CITY OF ALBUQUERQUE

August 19, 2005

Re: Certification Submittal for Final Building Certificate of Occupancy for
Atrisco Business Park, Big Lots, [J-10 / D32]
465 Coors Blvd NW
Engineer's Stamp Dated 08/17/05

EXISTING SD MH
GRATE=98.55
INV. (N)=90.97
INV. (S)=90.95
INV. (E)=91.10
CONNECTION
PERMIT WITH
SO-19

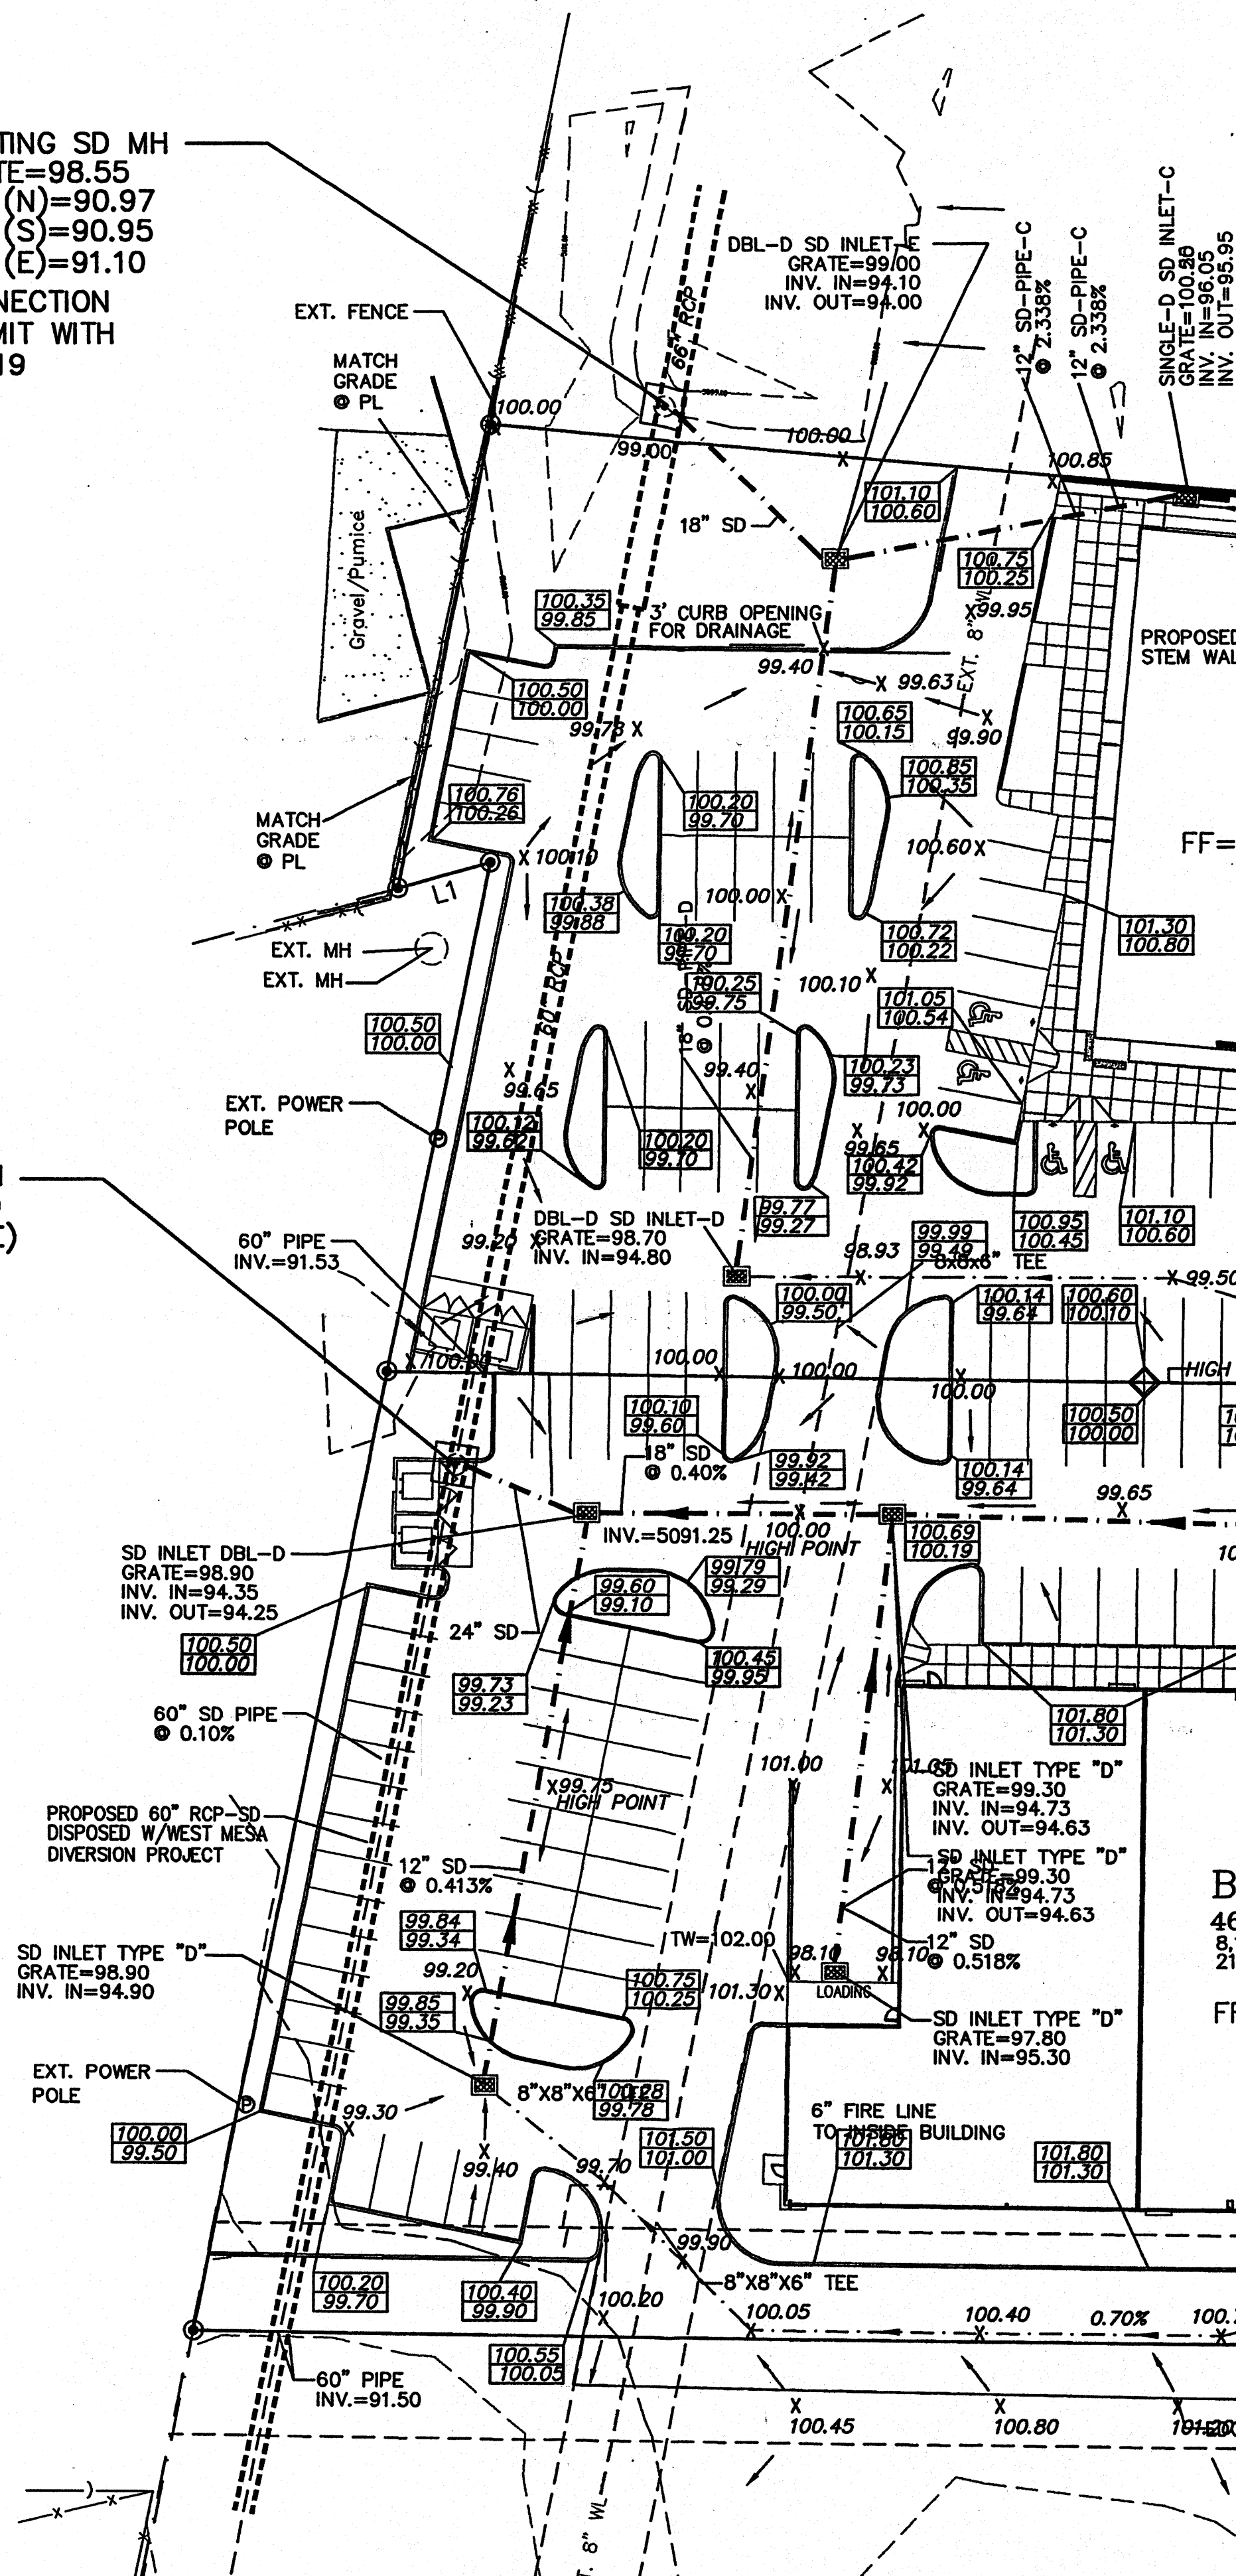
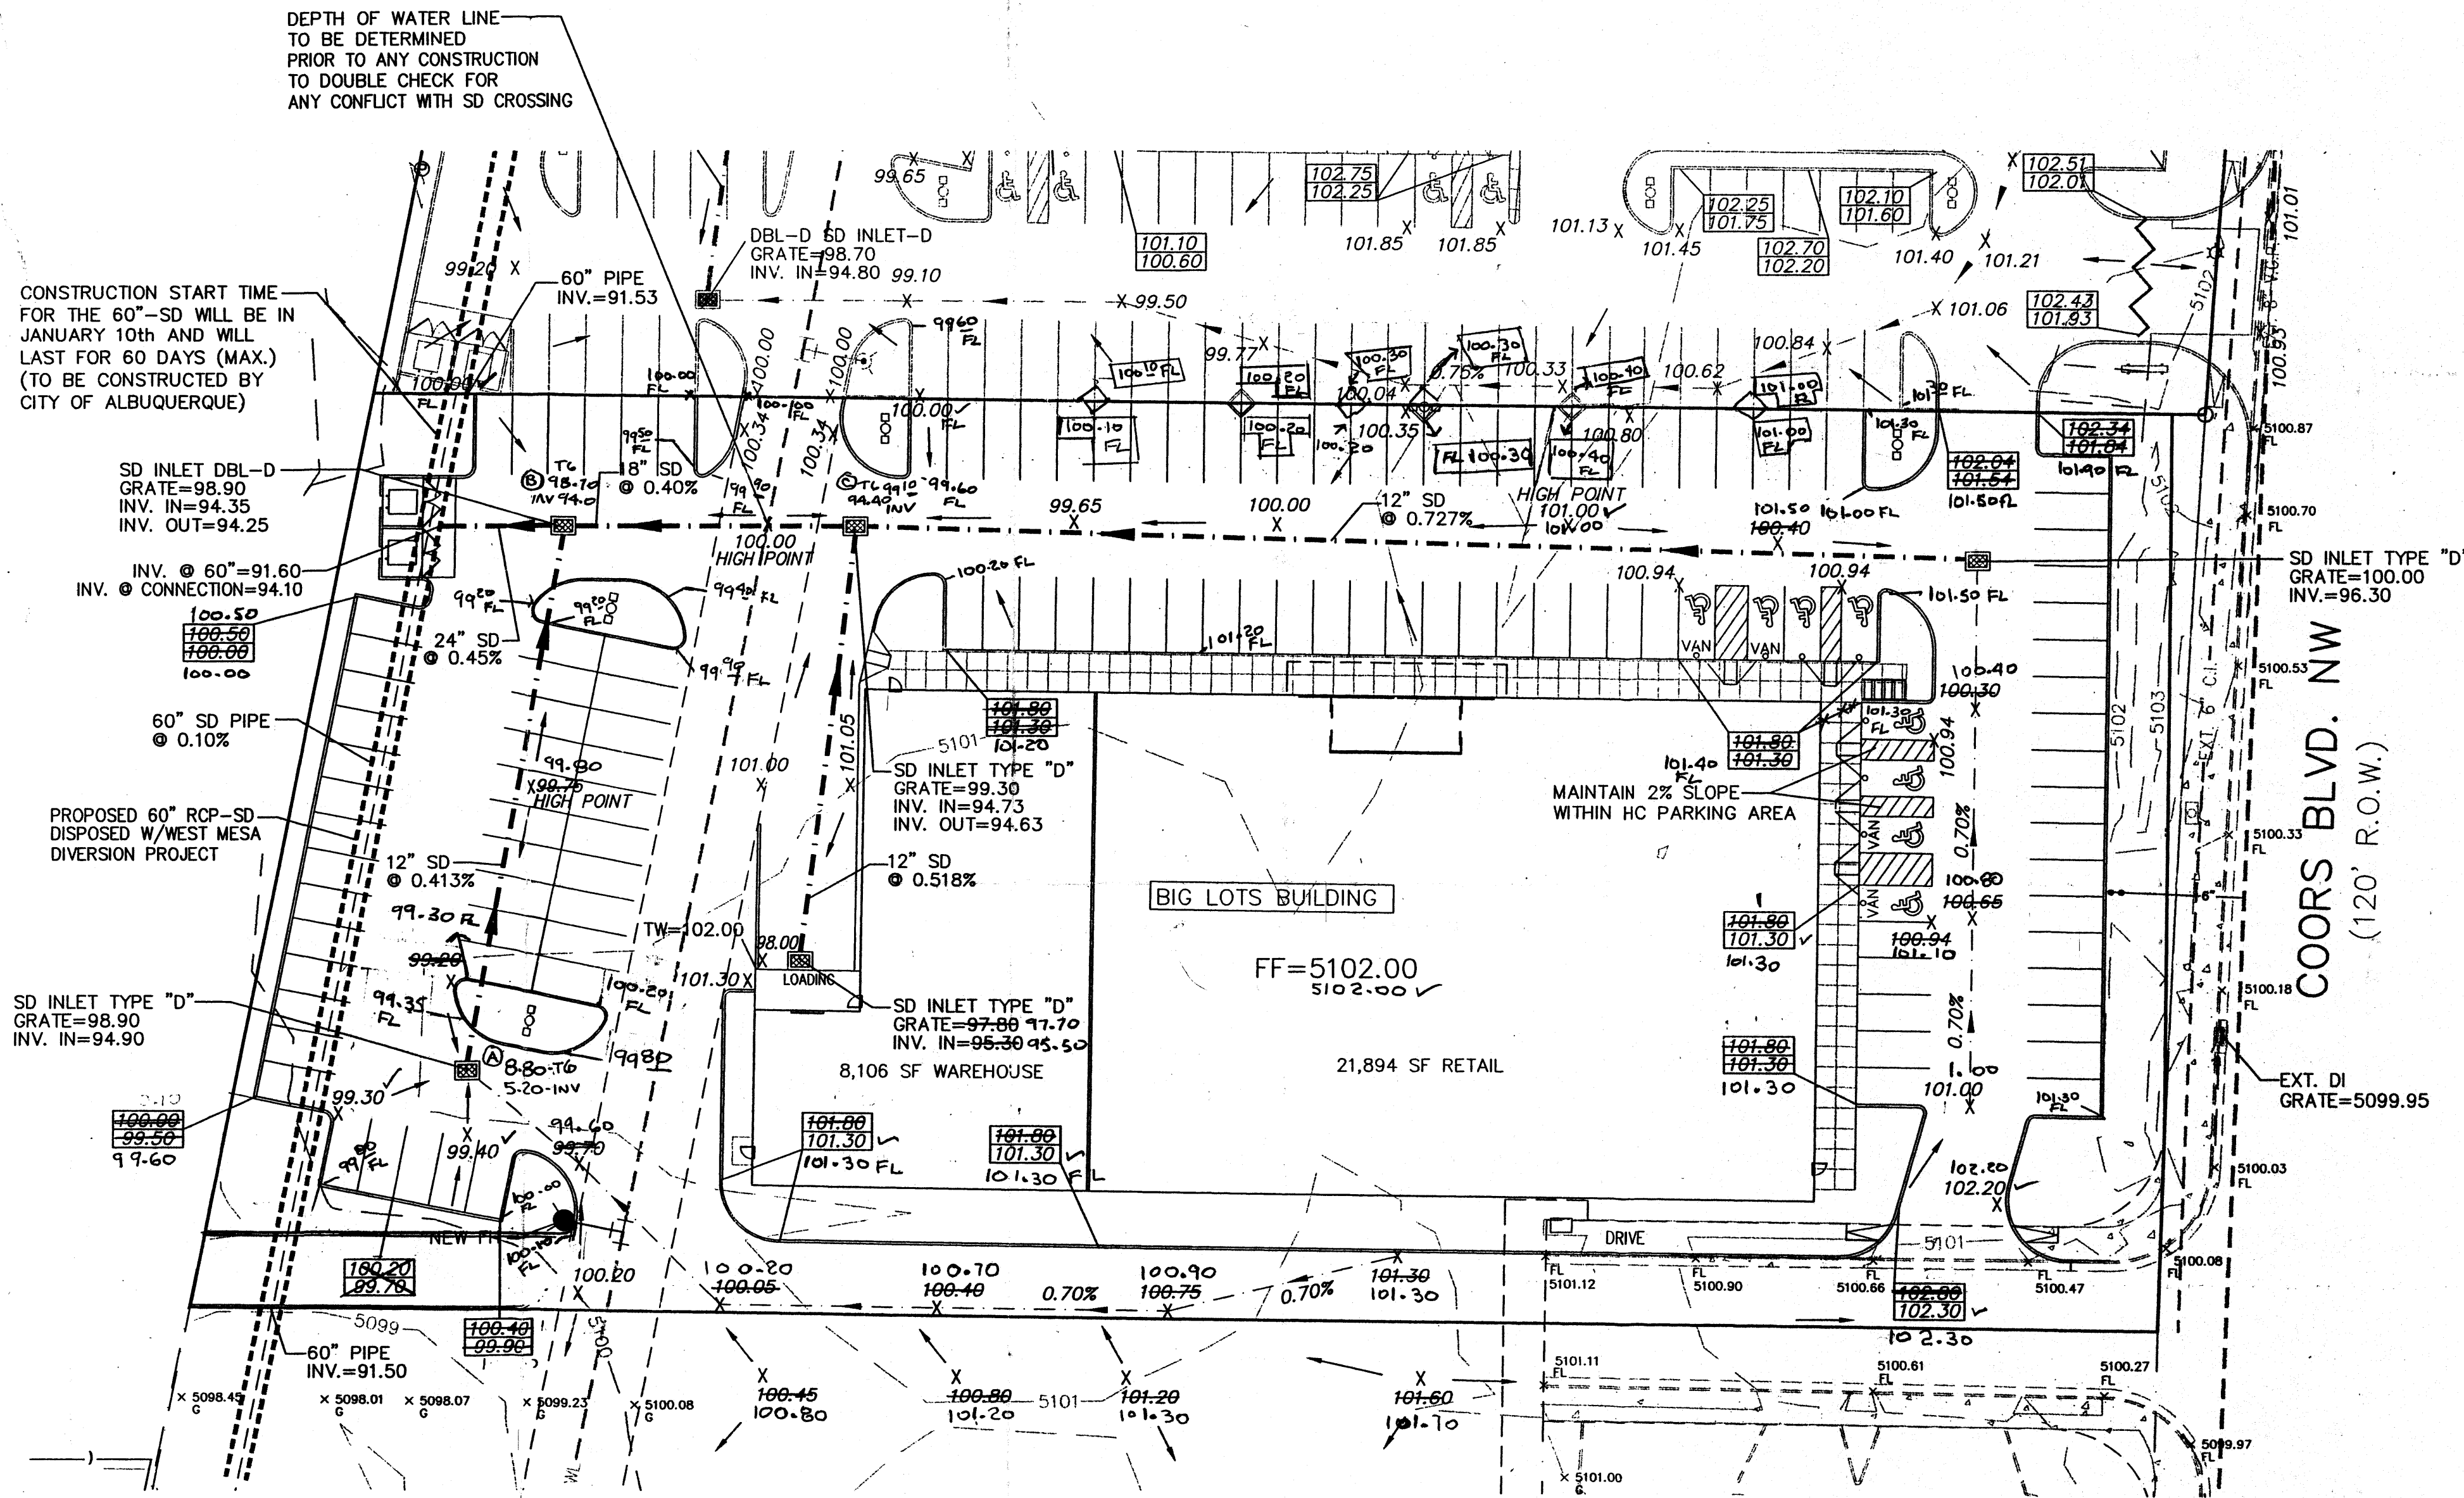
- Show detail for connection to existing storm drain on plan.
- Provide addresses for both sites connecting to existing storm drain.

DETAIL CONNECTION "A"

DETAIL CONNECTION "B"
